*Sizewell C (SZC)*

Planning Inspectorate Reference: *EN010012*

*Deadline 5 – 23 July 2021*

East Suffolk Council comments on Deadline 3 and 4 submissions from the Applicant

Figure 6: Topographic maps of the current and proposed SCDF topography.

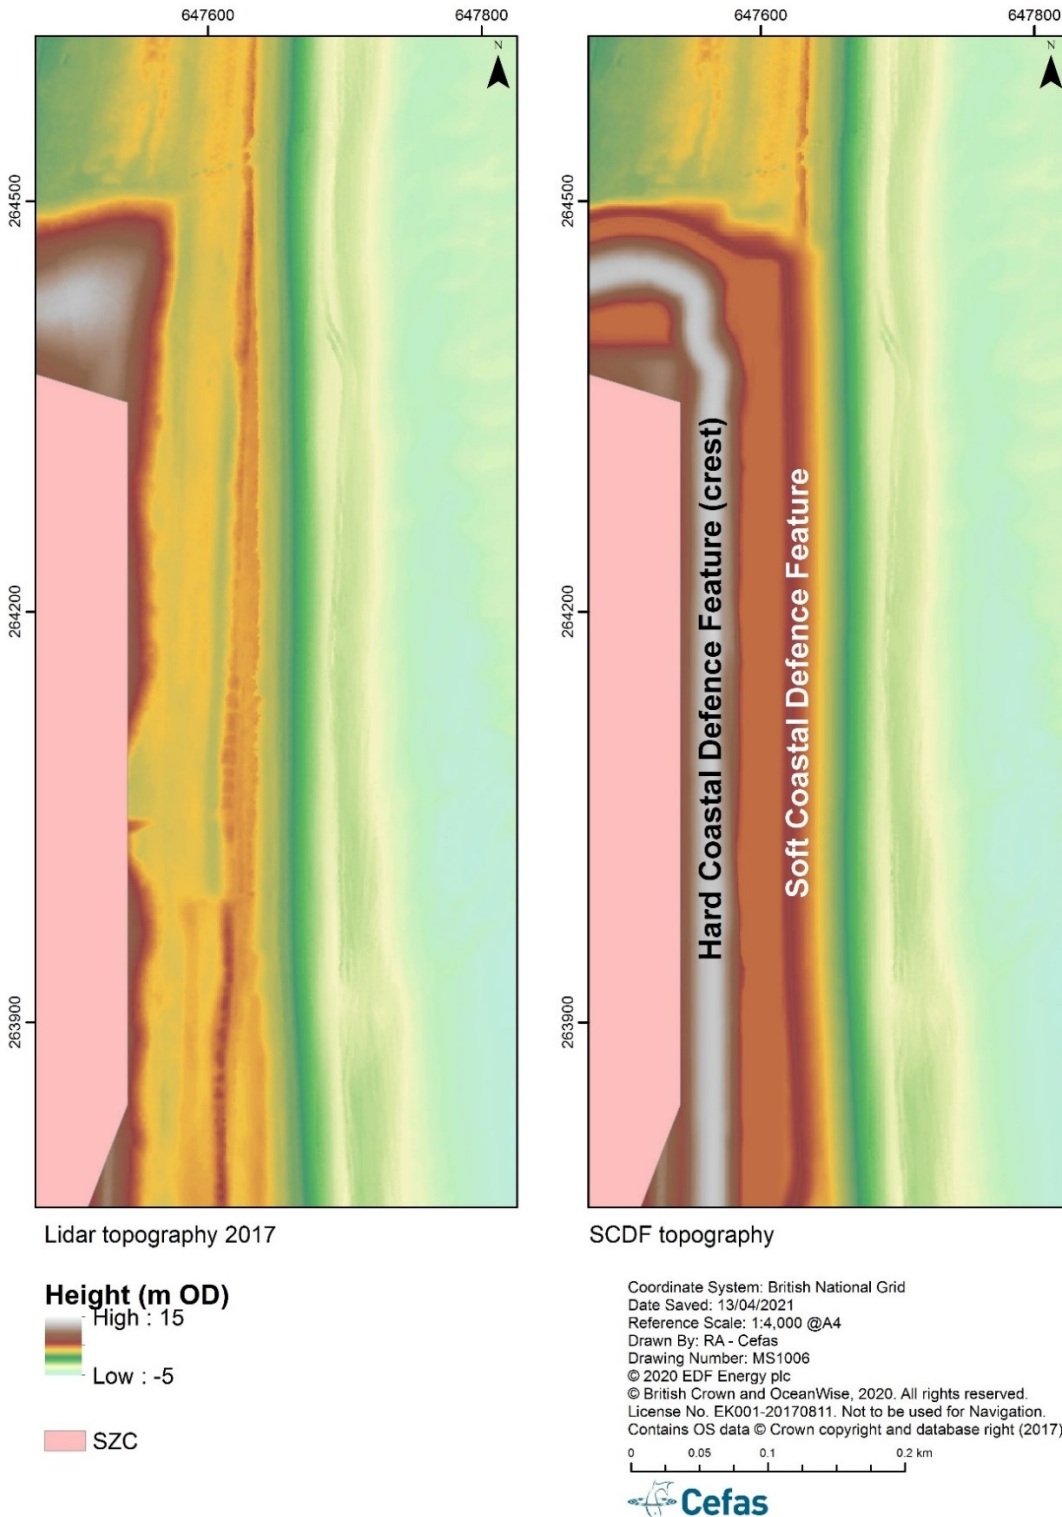
17	Fig. 6		<p>The colour contours clearly show how the SCDF would wrap around the north end of the HCDF, turning westwards / landwards at the end of the developed site.</p> <p>From a safety perspective, the coastal defence cannot be allowed to be breach should shoreline retreat progress up to and beyond the HCDF (outflanking). Were this situation to arise then continuity of natural longshore transport towards Thorpeness would be interrupted (notwithstanding secondary mitigation).</p> <p>The HCDF plan position, does not show the latest HCDF design seen in the Engineering report (3/6) and updated Drawings submitted at D3 that has a seaward kick out at the South end.</p>	<p>Clarify/comment on the how this situation might develop and be countered if/when the situation occurs.</p> <p>Update plans and SCDF volume calculations based upon latest drawings showing HCDF plan position.</p>
20	2.3.2	<p><i>Overtopping per se is not of direct concern for the functioning of the SCDF, since its purpose of avoiding disruption to longshore shingle transport due to HCDF exposure will not be affected. However, overwashing of quantities of sediment sufficient to alter or mobilise the crest could lead to breaching and affect the integrity and maintenance frequency of the SCDF. To mitigate this, the crest elevation should be high enough to avoid heavy overwashing.</i></p>		<p>Explain how breaching of the SCDF crest will affect the SCDF integrity and maintenance frequency.</p> <p>Clarify / confirm, whether the Vbuffer will be subject to a condition for retention / reconstruction of the designed crest height and width.</p>
